Sunaana event plan

Tue, Feb 14, 2017 at 9:33 AM

Forefront Brick South Sun Life

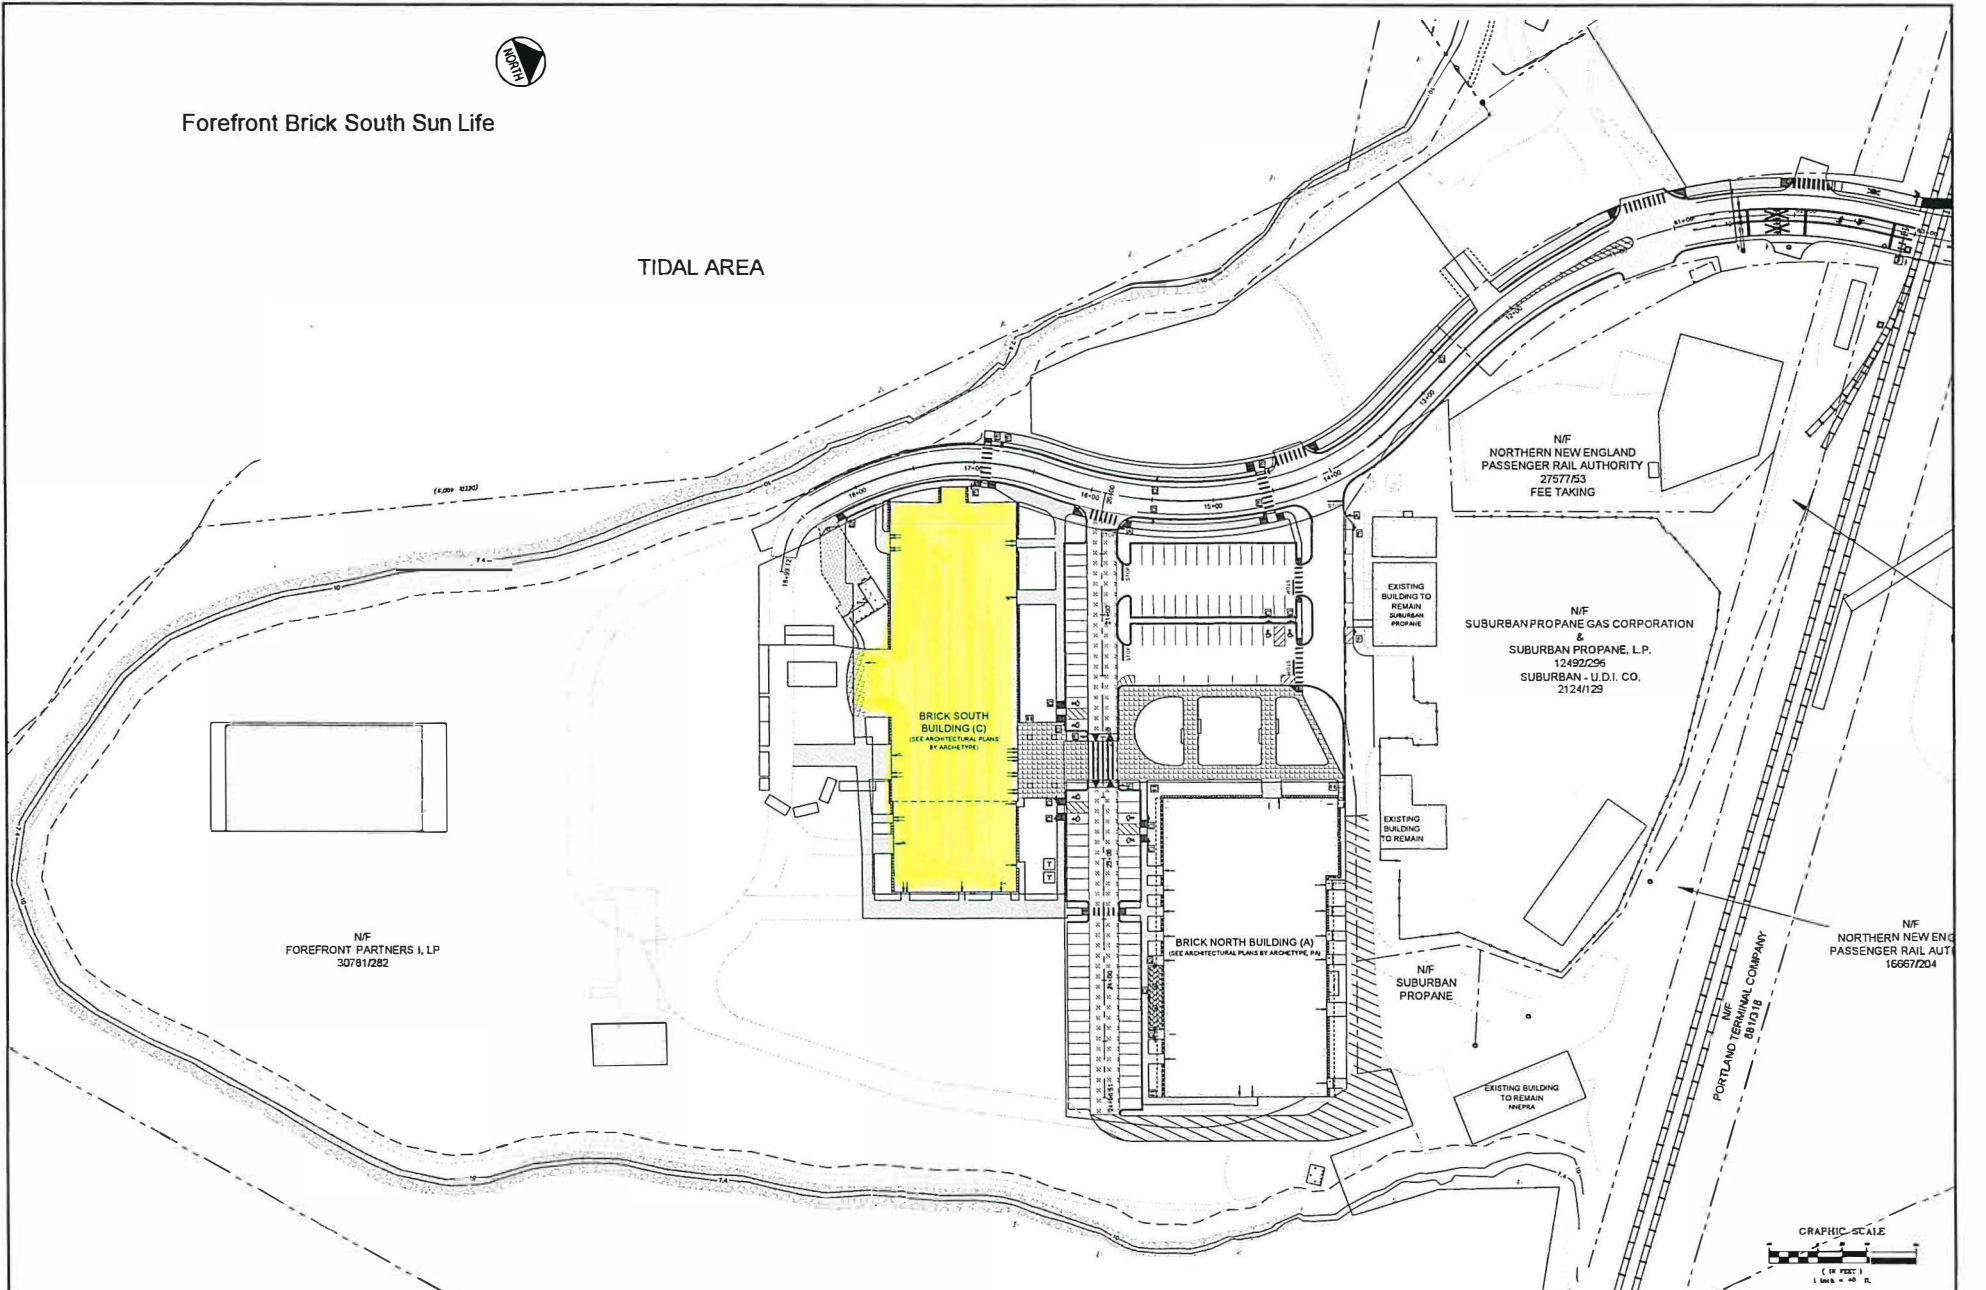
Quick question the the layout plan for Sunaana - the outdoor plan shows shipping containers being used around the outdoor ice bar area. Are these shipping containers already on site? Are they just being used as a barrier or will people be entering them?

These will be the containers we already use onsite with the concerts and ice rink as a barrier with the exception of 2 refrigerated containers that will be cold *storage* only. These 2 containers will come in for the event and leave after the event. Please feel free to reach out with any further questions.
